SUMMITCARE SENIORS HOUSING JAMISTOWN, PENRITH

SSDA (SSD-68603709) - DPHI Request for Additional Information

TTW's responses to the Department of Planning, Housing and Infrastructure (DPHI)'s request for additional information on the Flood Impact and Risk Assessment (FIRA) and Flood Emergency Response Plan (FERP) for SummitCare Seniors Housing, Penrith (SSD-68603709) are provided below.

Figure 19: PMF flood depths and levels at the site under post-development conditions

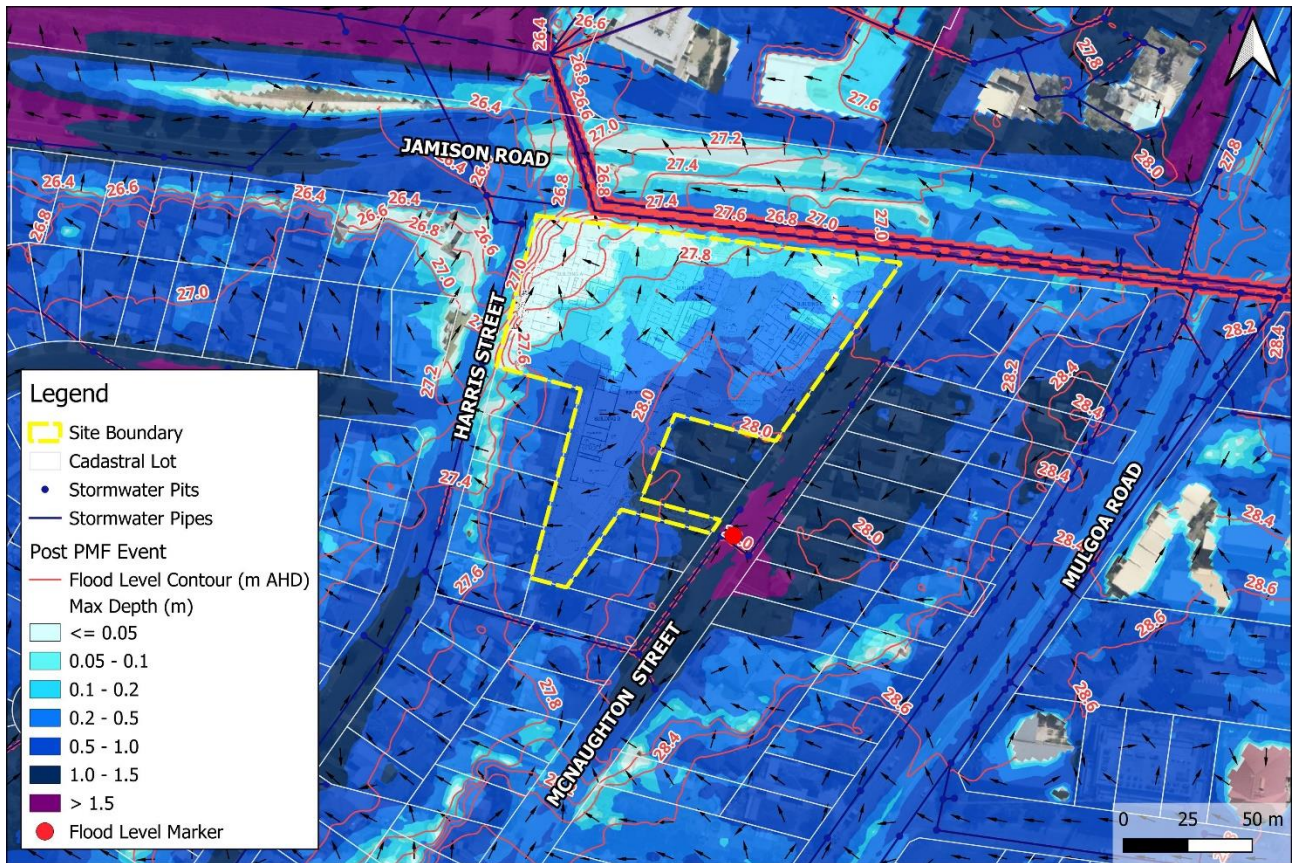
Item	Comment	TTW Response
Department of Planning, Housing and Infrastructure – 17 March 2026		
1	The Flood Emergency Response Plan (FERP) indicates that in a local catchment probable maximum flood (PMF) event, flooding would reach the site within 15 minutes and inundate the habitable floor levels of the Residential Care Facility suites after one hour. The Department considers this timeframe insufficient to monitor site conditions, implement a shelter-in-place response, and relocate high-care residents to higher levels. The Department recommends that the design of the development be revised to ensure that the RCF suites are located above the PMF level. This may be achieved by relocating RCF beds to the first floor of the development.	Relocating RCF suites above the PMF level is not considered operationally feasible. This risk must be balanced against the more frequent, day-to-day need for high-care residents to be located on the more accessible ground floor, noting the PMF represents an extreme, very low-probability event. The facility must primarily function safely and effectively under normal conditions. Locating high-care residents at ground level ensures appropriate accessibility and care delivery, including during other emergency situations, including: • More efficient access to the ambulance bay when emergency care is required • Ground floor access is preferable for high-care residents in the event of a fire Emergency procedures will be in place to manage relocation of resident to higher levels in the unlikely event of a very rare local catchment flood. It is recommended that the elevators run on backup power so high-care individuals can be relocated to Level 1 during power outages (prior to above-floor inundation). This has been noted in TTW's updated FERP (refer to Section 3.2.3 in Revision 2).
